From: Patel, Uday [Uday.Patel@lancashire.gov.uk]
Sent: 04 March 2013 13:35
To: Claire Booth
Cc: planning
Subject: Application 3/2013/0071 - New access off Settle Road into a parcel of agricultural land and the creation of a stone track to allow access for agricultural operations - Calder Farm Settle Road Bolton-by-Bowland Clitheroe BB7 4NT

Planning Application reference: 3/2013/0071

Proposal: New access off Settle Road into a parcel of agricultural land and the creation of a stone track to allow access for agricultural operations

Location: Calder Farm Settle Road Bolton-by-Bowland Clitheroe BB7 4NT

PLAN

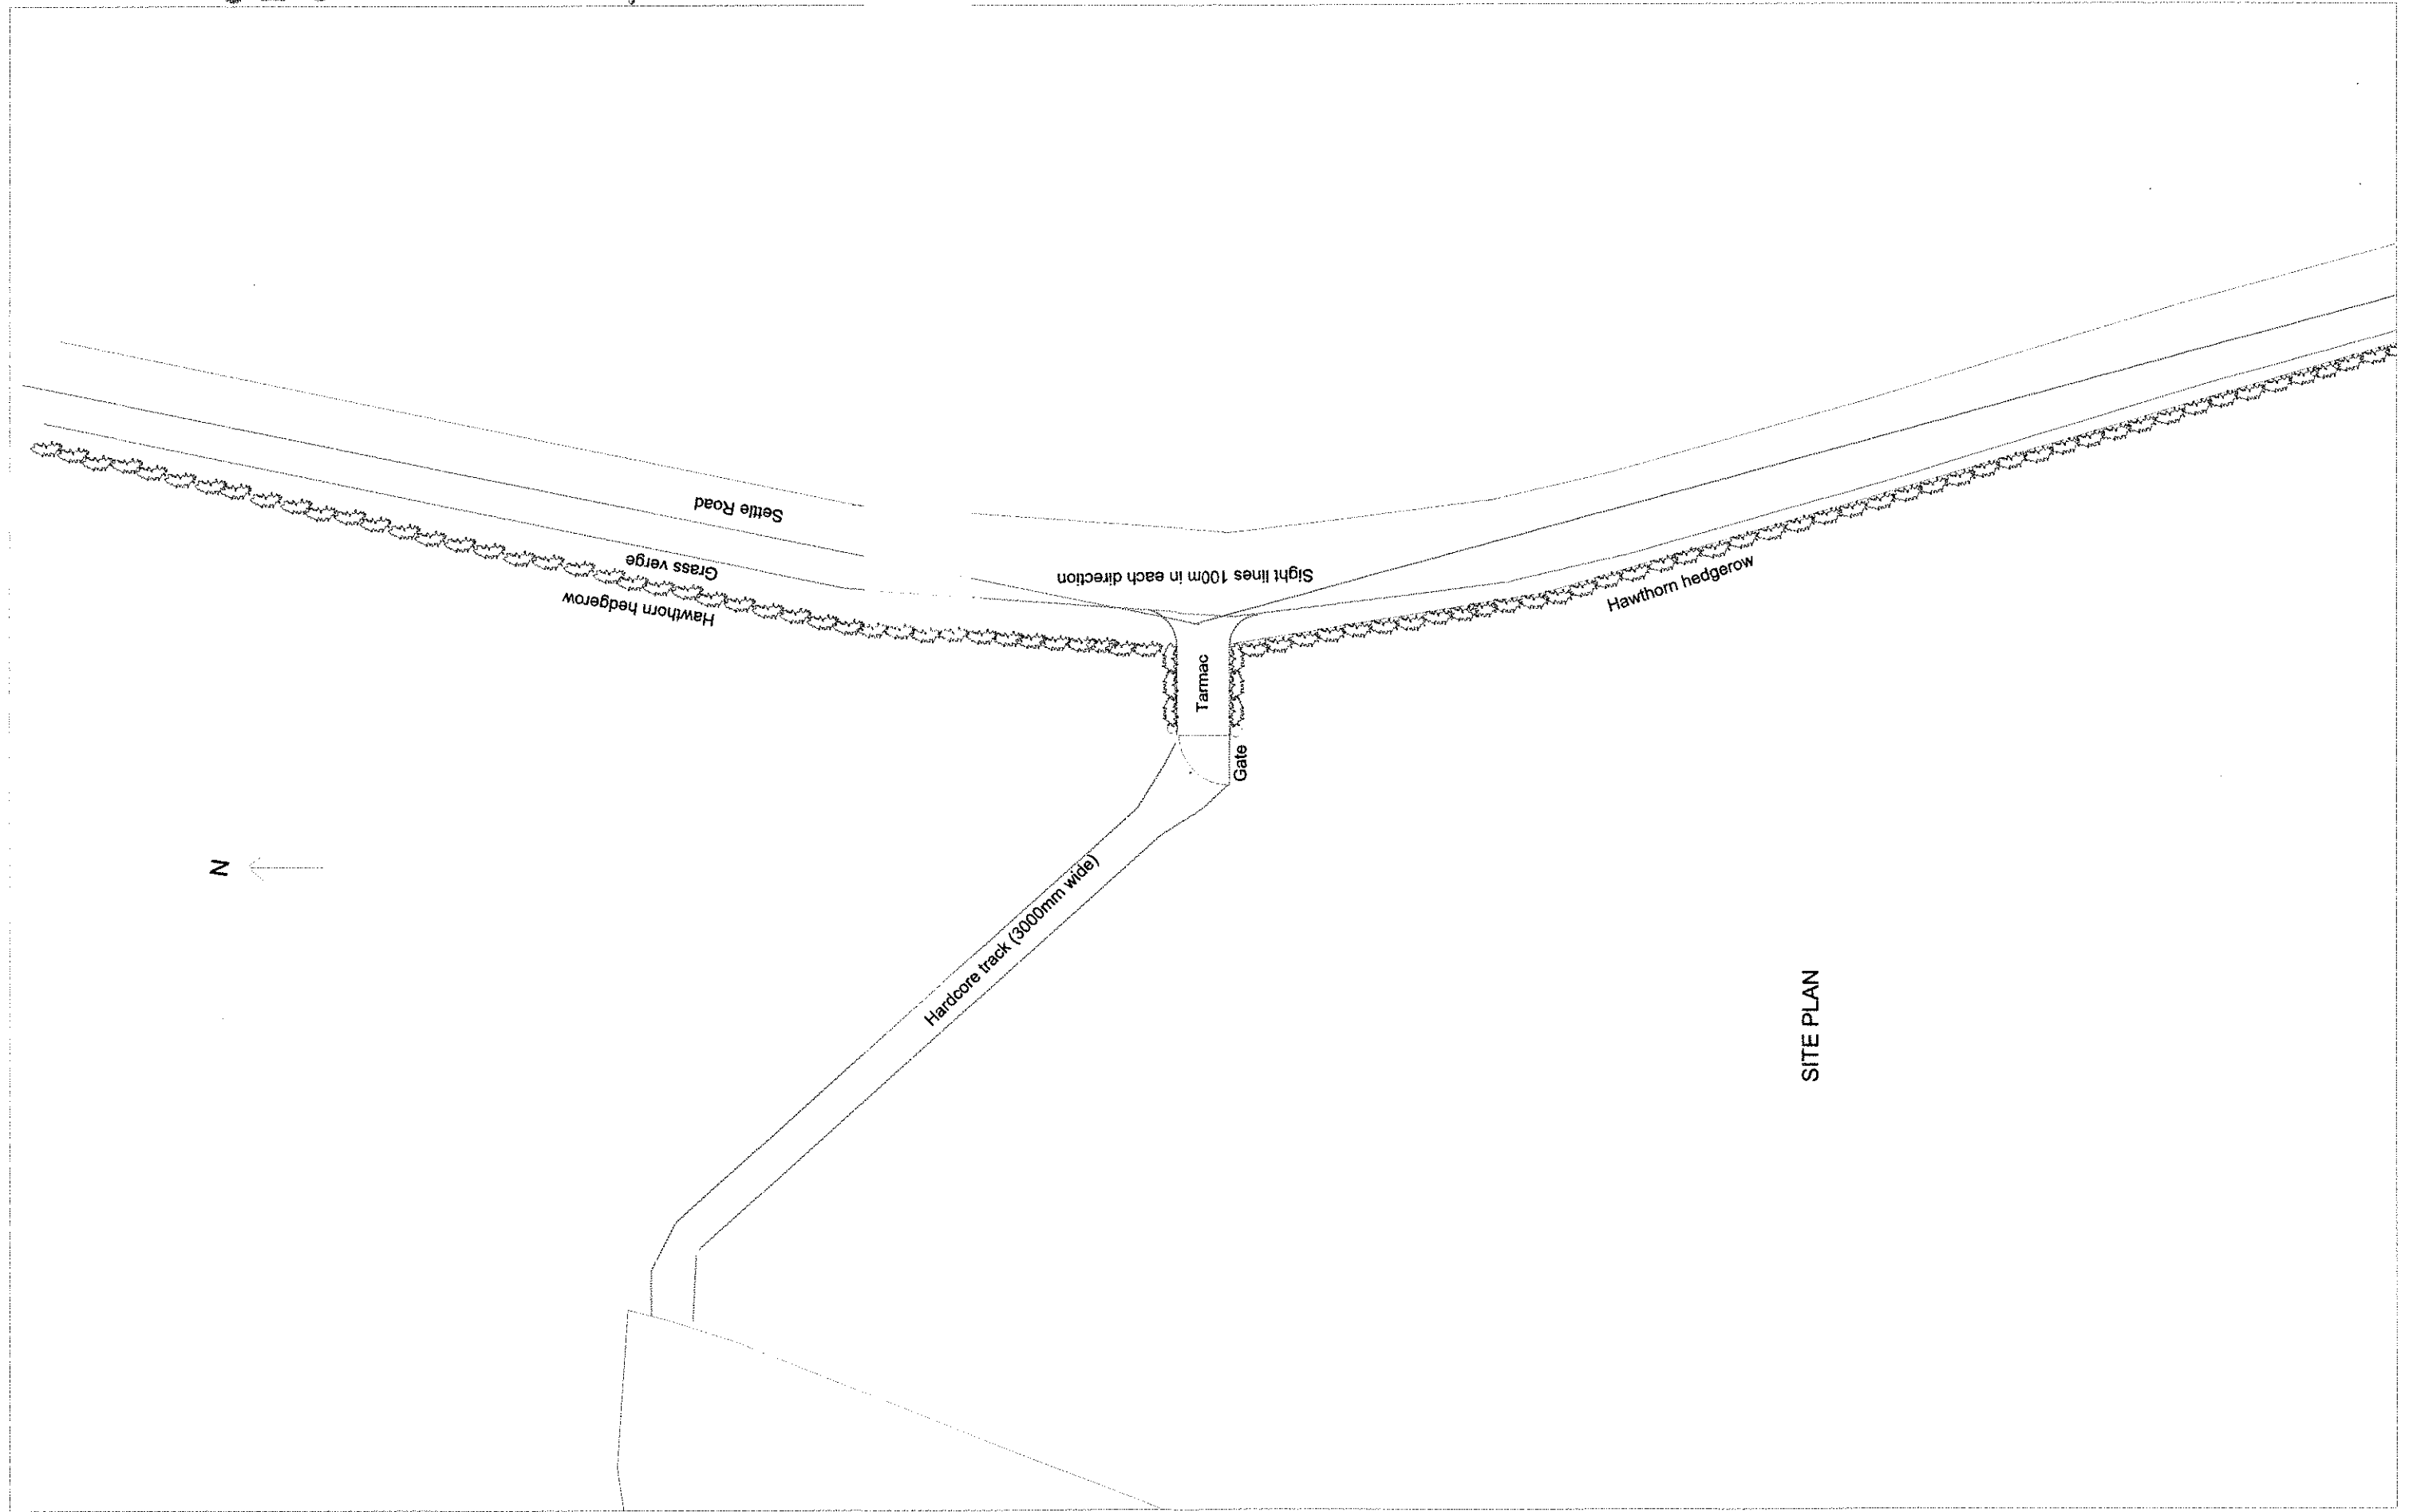
Before the access is used for vehicular purposes, any gateposts erected at the access shall be positioned 10m behind the nearside edge of the carriageway. Visibility splay measured 4.5m behind the existing arbitrary kerb line of Settle Road along the centre line of proposed access along Settle road in either direction of access shall be kept clear of all the vegetation/hedge/wall/fence/any such obstruction which may limit or obstruct the existing visibility along the Settle Road in North and South direction of the proposed access. Reason : The existing visibility is approximately 119m in south direction and 225 m in North direction. Although it is considered of sub standard nature with respect to the speed of the road (60mph), considering the speed of vehicles on the Settle Road as well as limited use of the access to only farm vehicles, it is considered acceptable in this instance.

Before the access is used for vehicular purposes, that part of the access extending from the highway boundary for a minimum distance of 10m into the site shall be appropriately paved in tarmacadam, concrete, block pavements, or other approved materials. Reason: To prevent loose surface material from being carried on to the public highway thus causing a potential source of danger to other road users.

The layout of the development shall include provisions to enable vehicles to enter and leave the highway in forward gear and the vehicular turning space shall be laid out and be available for use before the development is brought into use. Reason: Vehicles reversing to and from the highway are a hazard to other road users.

Before the development hereby permitted becomes operative, the existing hedge/fence on the highway frontage of the site to Settle Road shall be reduced to and be permanently maintained henceforth at a height not greater than 1m above the crown level of the carriageway of Settle Road. Reason: To ensure adequate visibility for the drivers of vehicles entering and leaving the site.
